## WEST SUSSEX COUNTY COUNCIL CONSULTATION

<b>TO:</b>	Arun District Council FAO: Hebe Smith
<b>FROM:</b>	WSCC – Highways Authority
<b>DATE:</b>	16 December 2024
<b>LOCATION:</b>	Broomhurst Farm, Lymminster Road, Lymminster, BN17 7QQ
<b>SUBJECT:</b>	LY/21/24/PD Prior notification under Schedule 2, Part 3, Class Q to change use of existing agricultural building to 1 No dwelling house.
<b>DATE OF SITE VISIT:</b>	n/a
<b>RECOMMENDATION:</b>	Advice

GROUND FLOOR PLAN AS PROPOSED 1:50

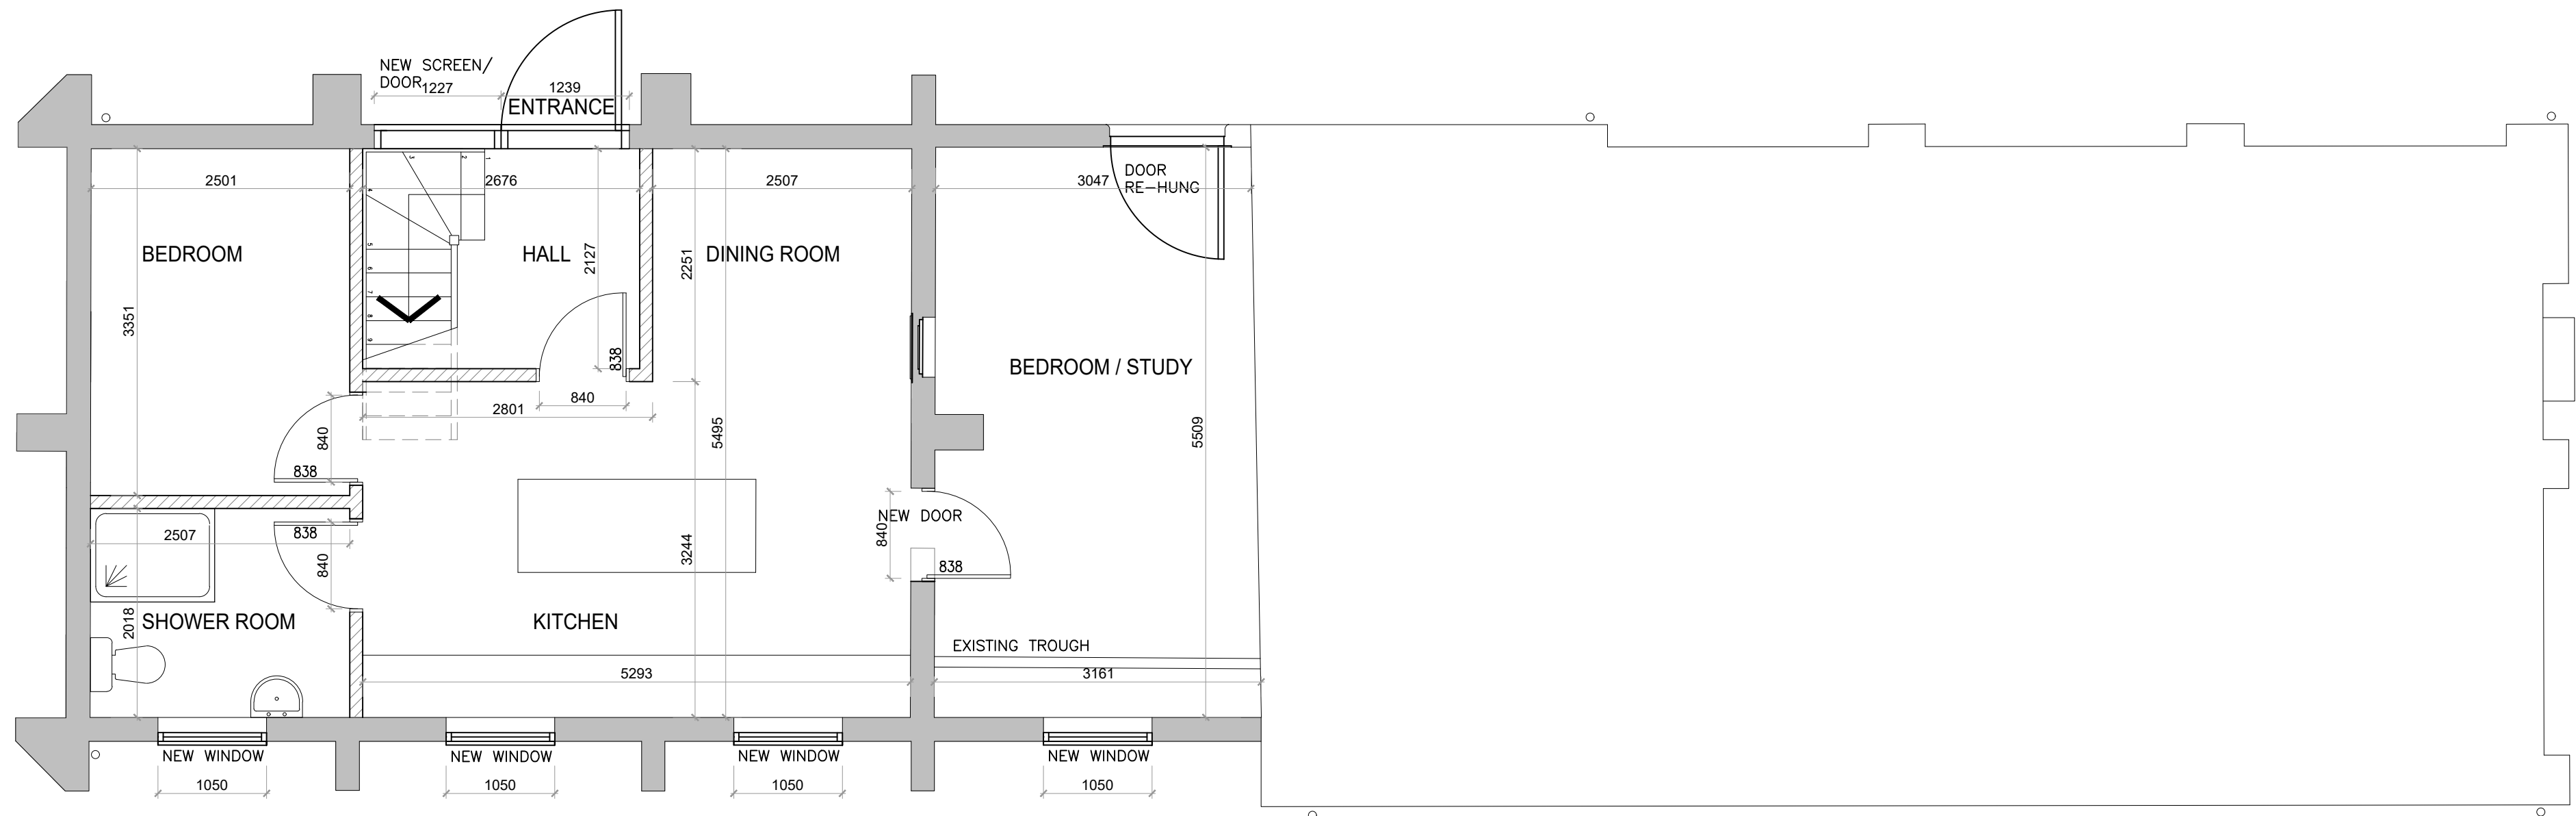
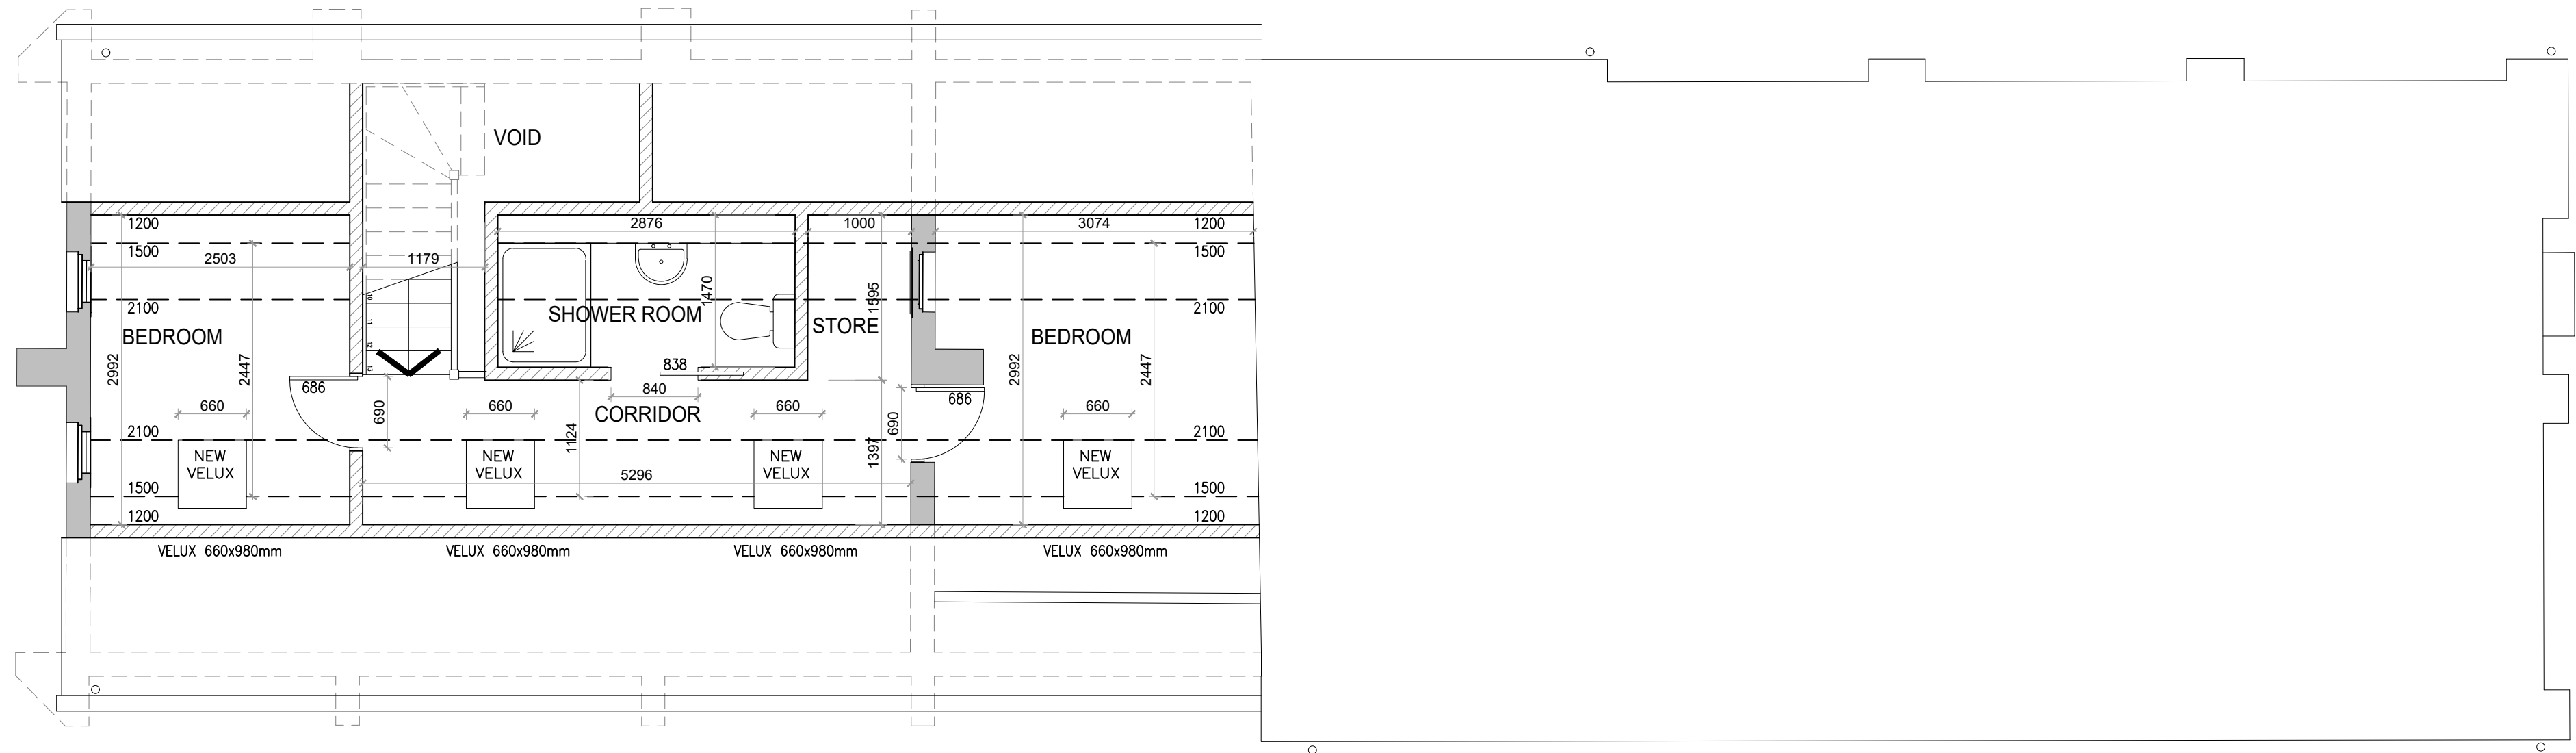
The plans do not demonstrate vehicular parking provision. A dwelling of this size in this location would require three car parking spaces to meet the Arun Parking Standards. There appears to be sufficient space at the site to accommodate vehicular parking and onsite turning appears achievable. The LHA would recommend that secure and covered cycle parking is provided for the dwelling to encourage sustainable transport methods.
